**A303 Sparkford to Ilchester Dualling
PINS Reference: TR010036**

**Joint Council Local Impact Report
23rd January 2019**

**Submitted by South Somerset District Council and
Somerset County Council**

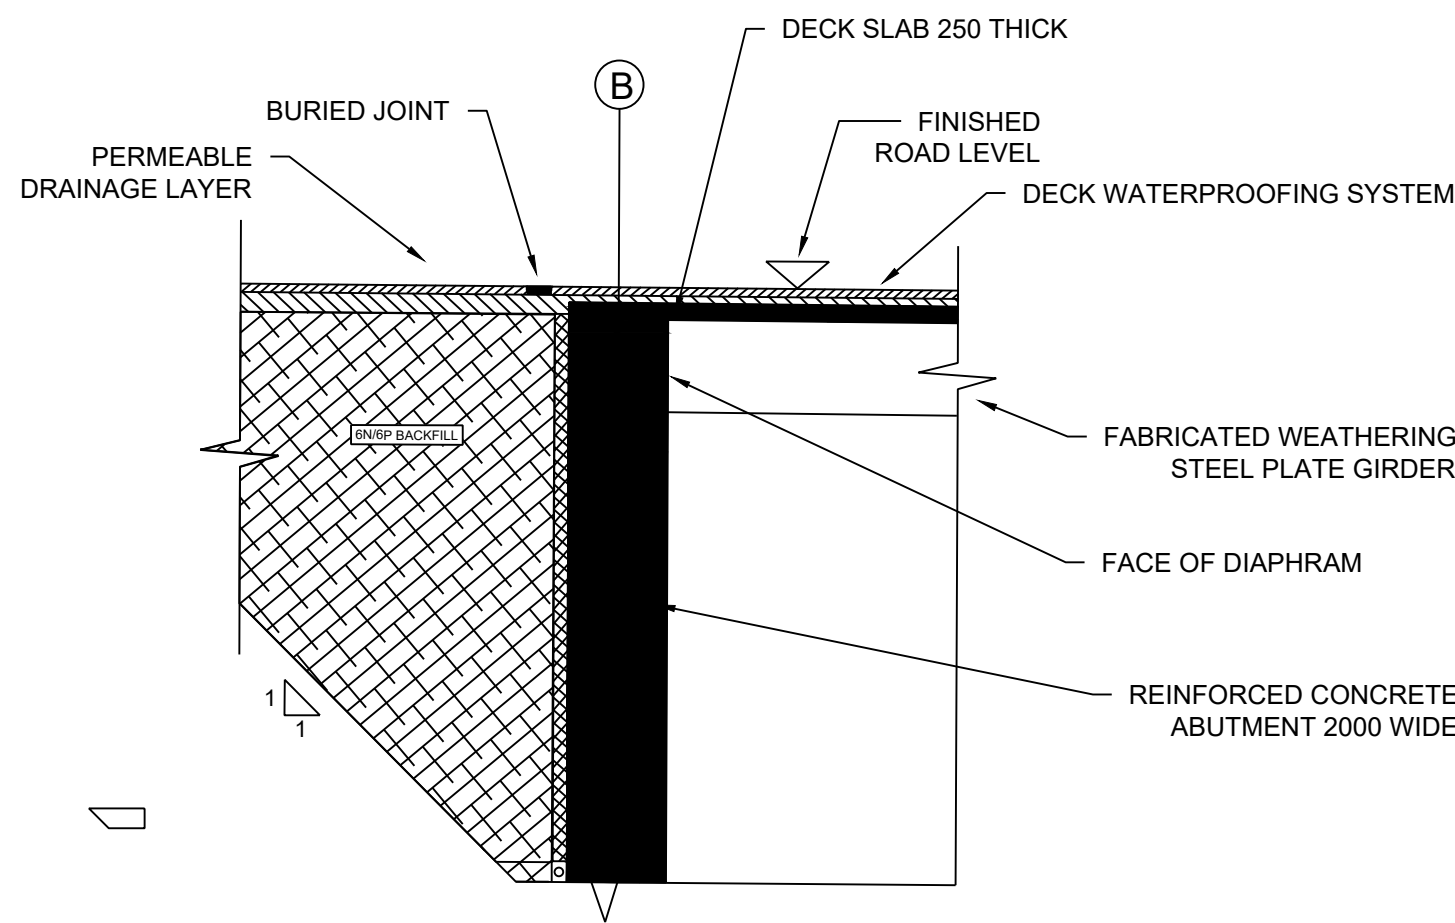
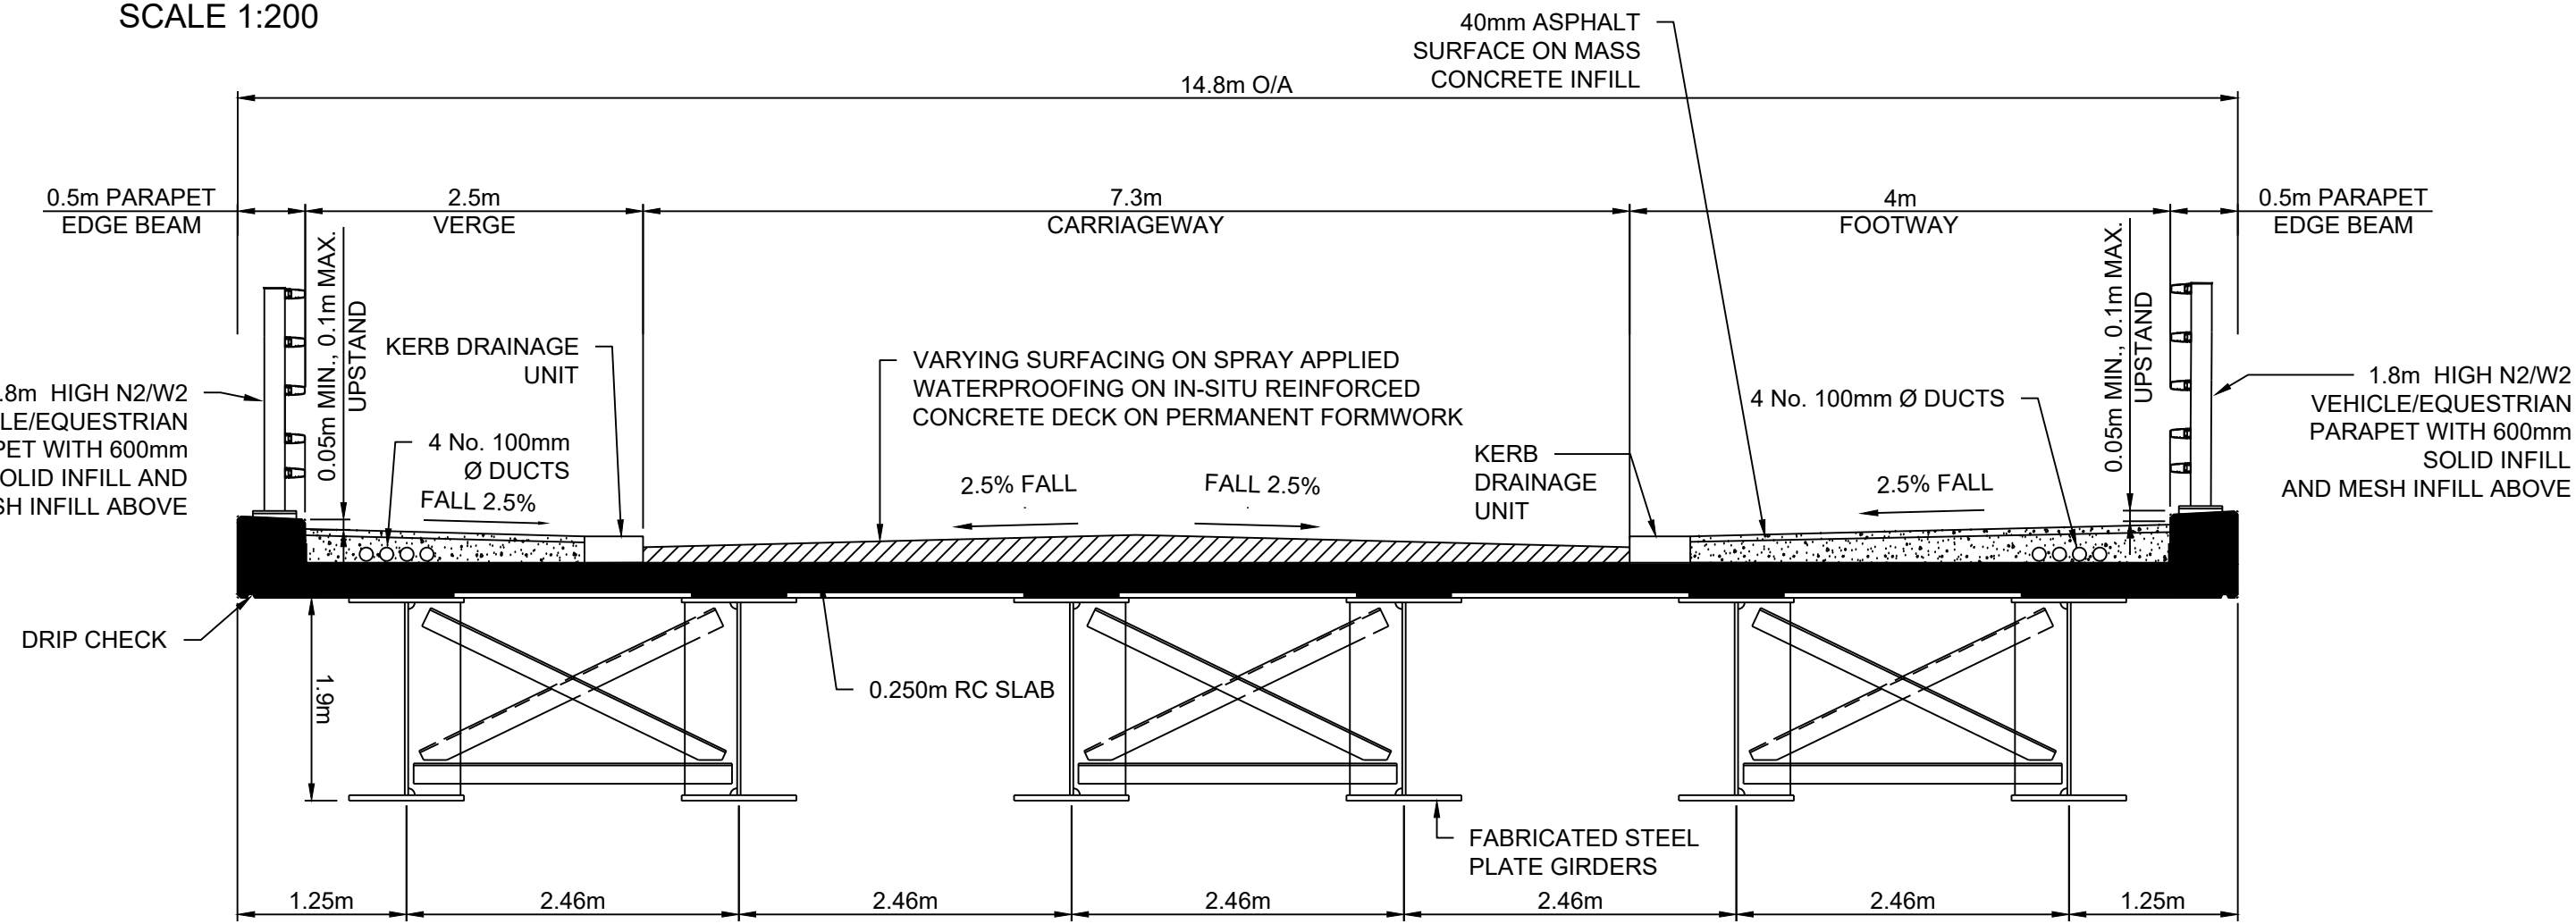
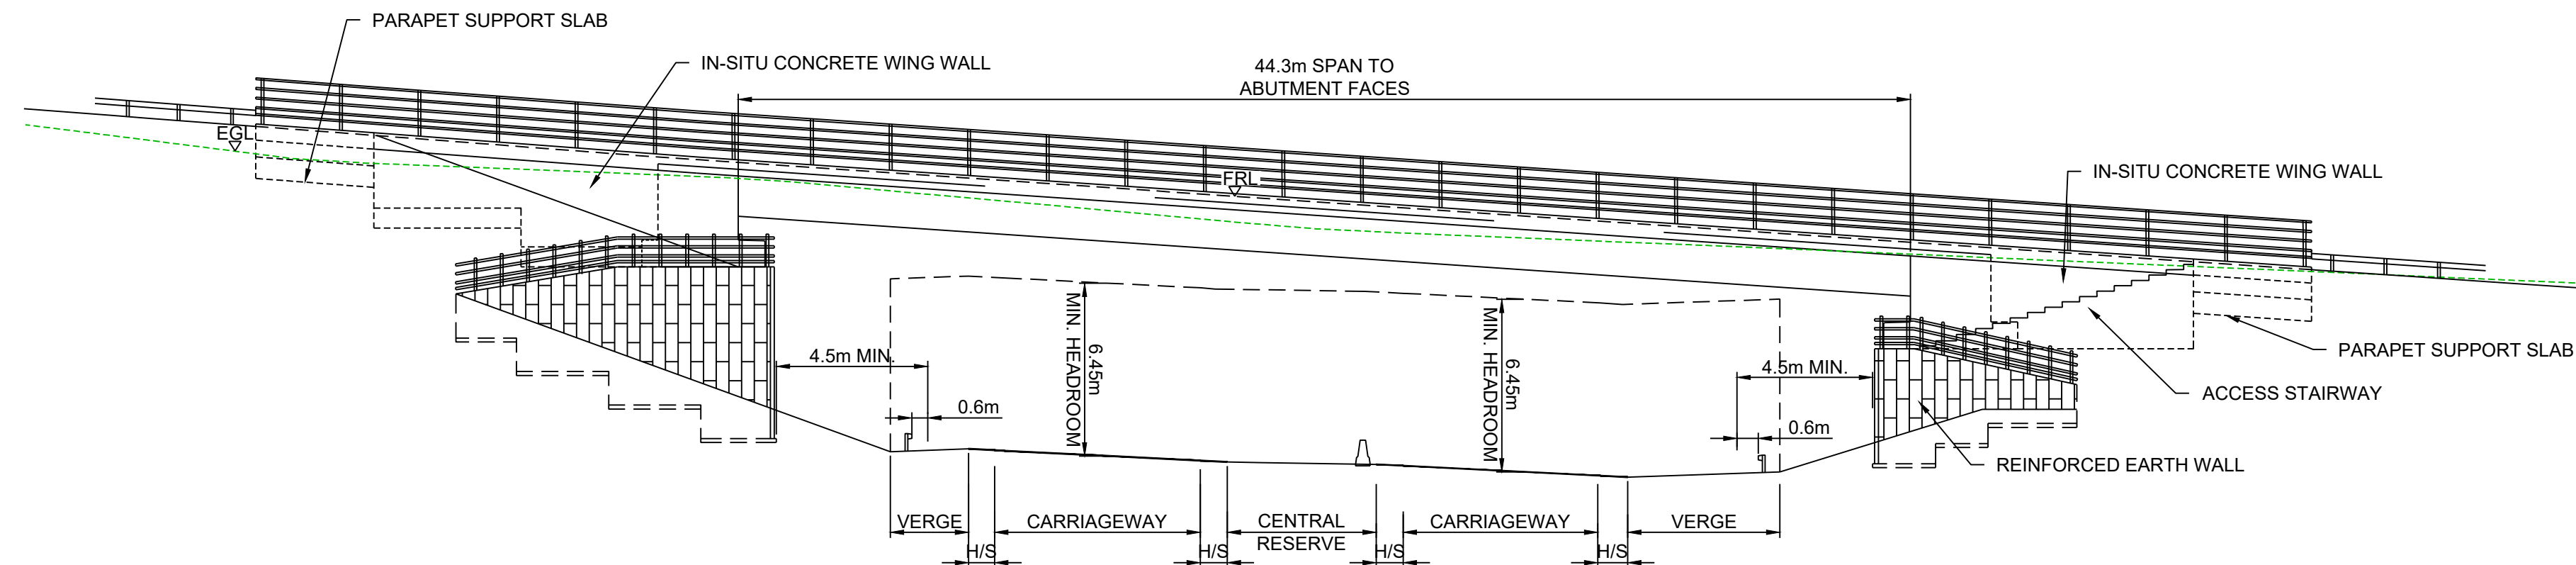
<ul style="list-style-type: none"> Concerns over vertical profile of Steart Hill (north) at its junction with Steart Hill Link, and its adequacy to carry quarry vehicles. SCC have requested that details of approved departures from standards on local roads are forwarded as soon as they are available. The “principles” of the drainage strategy have been accepted however no detailed design submissions have been issued to SCC to date. Highway lighting proposals are still under review. <p>SCC is concerned that the DCO as currently drafted does not include provision to allow SCC as the Local Highway Authority to approve detailed design matters as they relate to the Local Road Network (LRN). Requirement 12 as currently drafted provides that the local highway authority will only be <i>consulted</i> on detailed design matters which are not compatible with the preliminary design.</p> <p>Maintenance Phase:</p> <p>The current wording within the DCO does not reference any maintenance period post completion of the highway works and prior to new network becoming incorporated into the local road network. These sections include links to be de-trunked, where alterations to the existing network are proposed and where sections of new carriageway construction are outlined. SCC have concerns that should defects appear immediately post construction SCC would be liable for the associated maintenance costs. It is standard practice within SCC’s S278 legal agreements for a maintenance period to be served prior to adoption to limit risk to the adopting authority.</p> <p>It is essential that provision is made within the DCO for SCC to receive the necessary commuted sum payments for structures or other non-standard assets that require future capital maintenance as a result of the detailed design. To date, the applicant has not submitted design proposals to confirm if highway infrastructure is proposed that will, under normal circumstances require a commuted sum. Provision is needed within the DCO requiring the undertaker to pay any necessary commuted sums for structures to be adopted by SCC. The value of the commuted sum to be calculated by SCC.</p>		<p>The DCO should include provision for a minimum 12month maintenance period to be provided between the date of completion and the sections of carriageway becoming incorporated into the local road network. As per the provision currently outlined in 13(3).</p> <p>The DCO should include a provision to enable SCC to attract commuted sum payments for highway infrastructure requiring extra over maintenance.</p>		<p>Provide a mechanism(s) that ensures a minimum maintenance period of 12months and the provision of commuted sum payments to LHA where structures, and other non-standard assets, are offered to the LHA for adoption as a result of the scheme.</p>

Appendix 1 APPROPRIATE MITIGATION FOR STOPPING UP OF TERMINUS OF BRIDLEWAY Y 30/28 (EASTMEAD LANE)

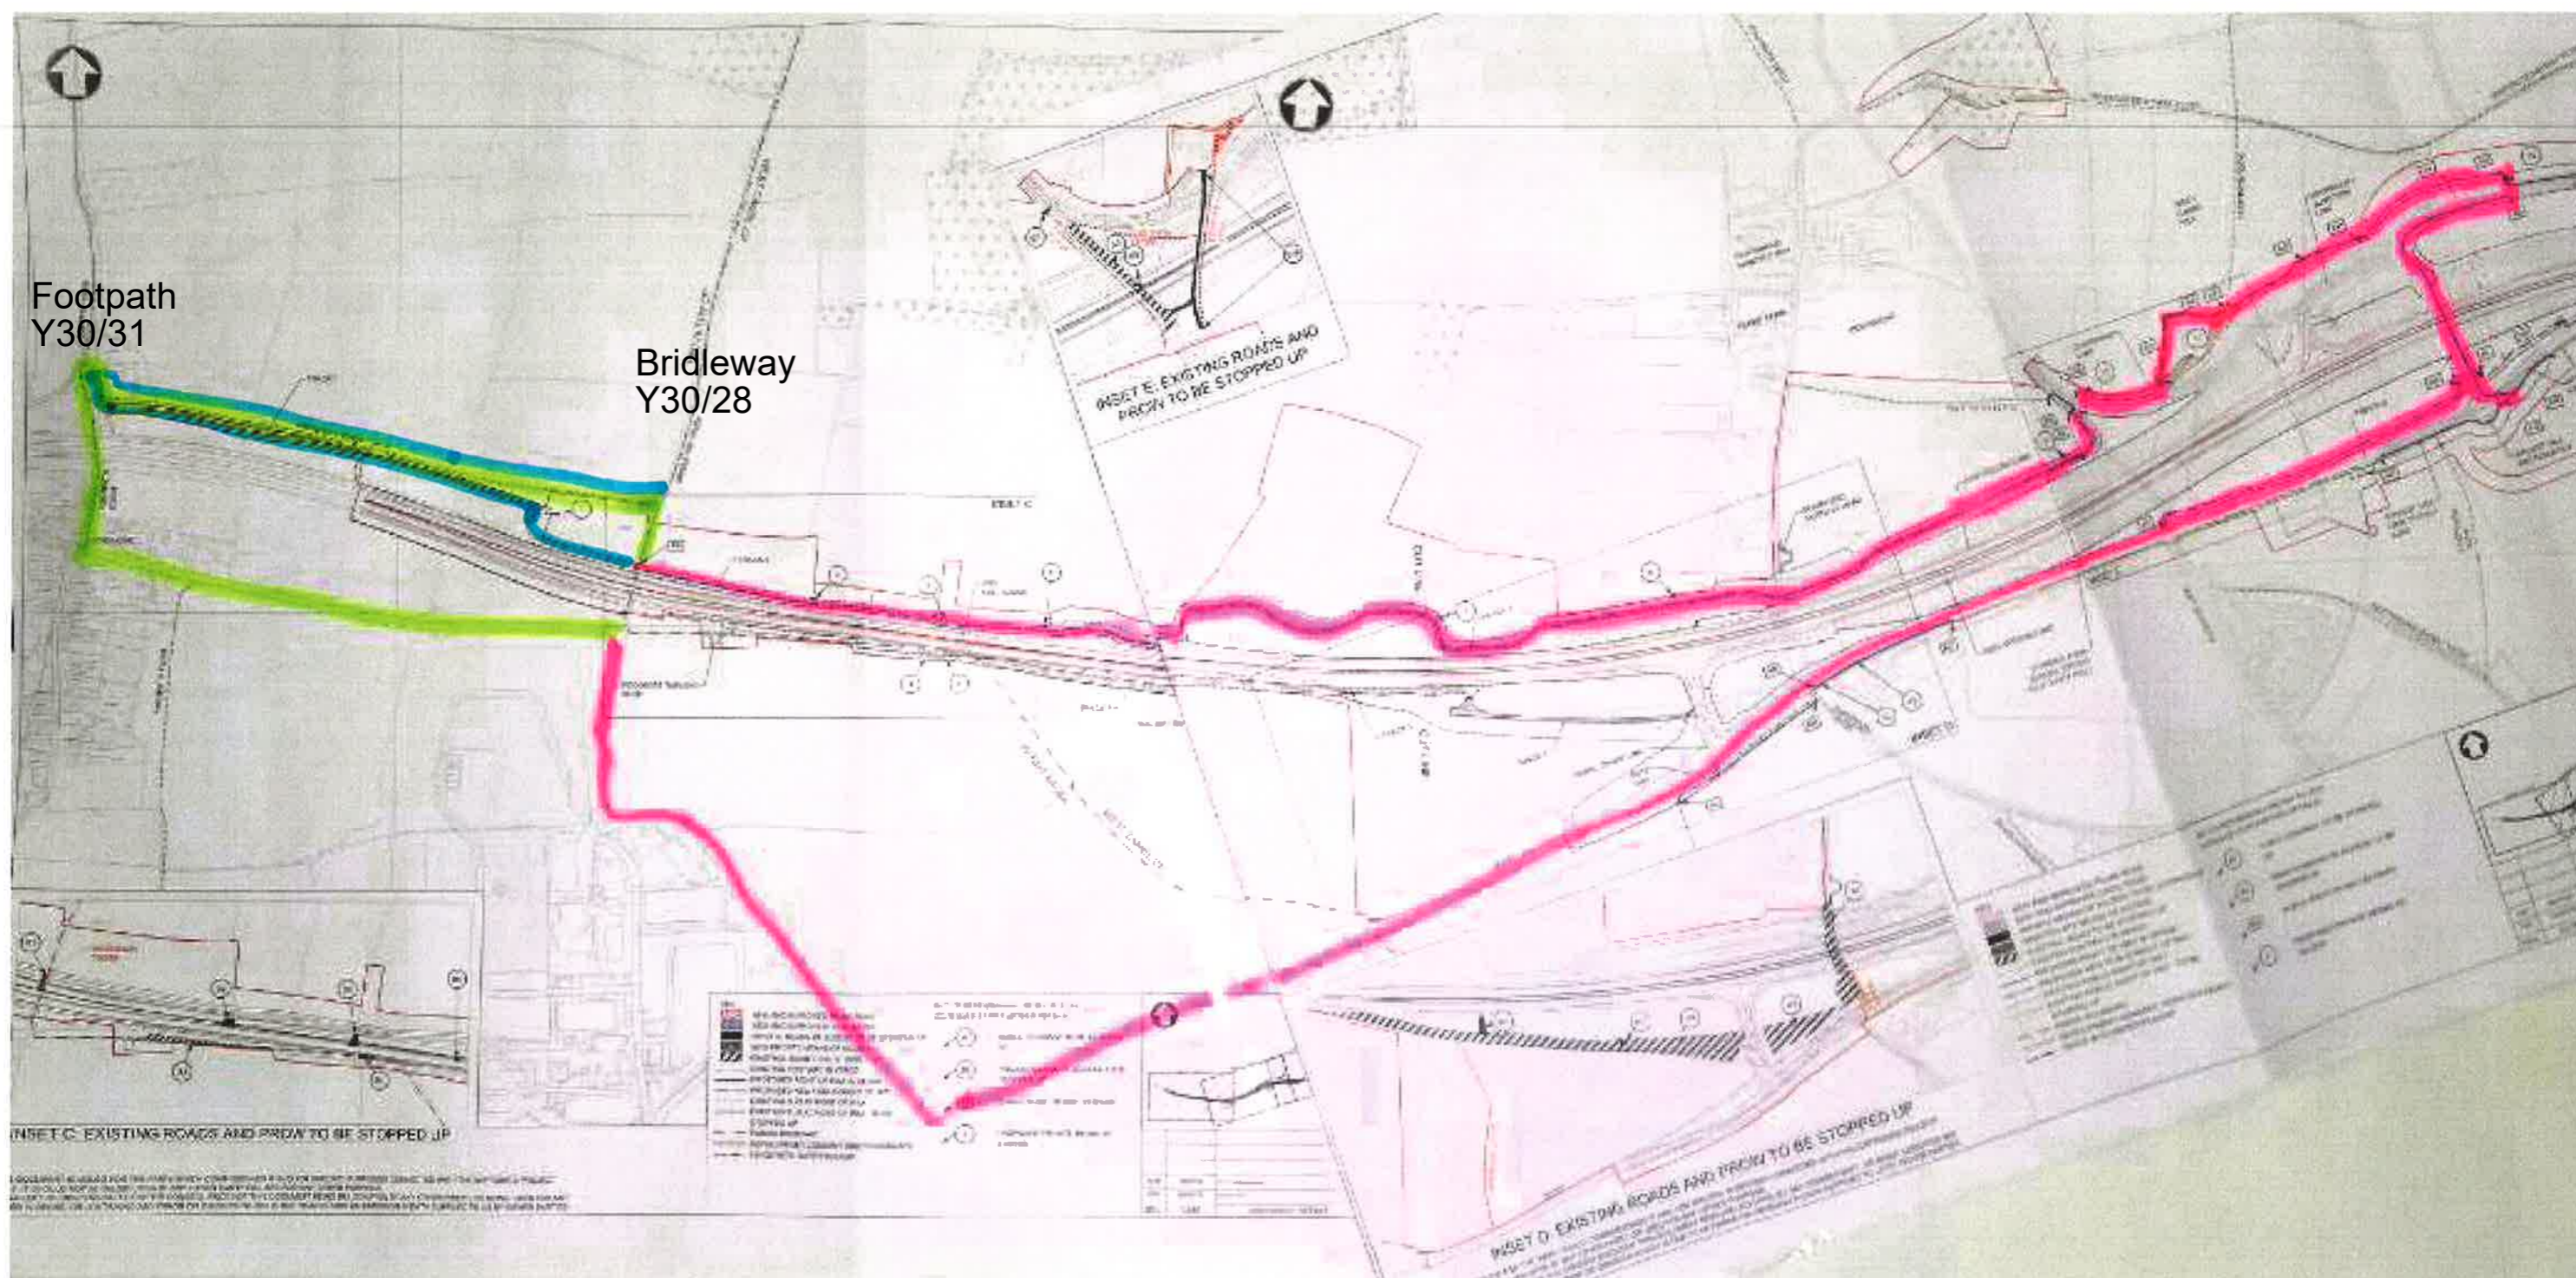
Concerns remain in respect of mitigation currently proposed by the applicant for the impact of the stopping up of the connection of Y30/28 with the A303. SCC has an alternative mitigation proposal which is considered to be more convenient and shorter in length for affected users. SCC has also raised concerns about how consideration is given to unrecorded rights that may exist which the development could interfere with.

There are 3 significant issues; i) the validity of the 1996 side roads order (issue 3), ii) the lack of appropriate mitigation for the stopping up in part of bridleway Y 30/28 (issue 4), and iii) having sufficient mitigation in place to address any unrecorded rights that may be impacted upon by the development (issue 6).
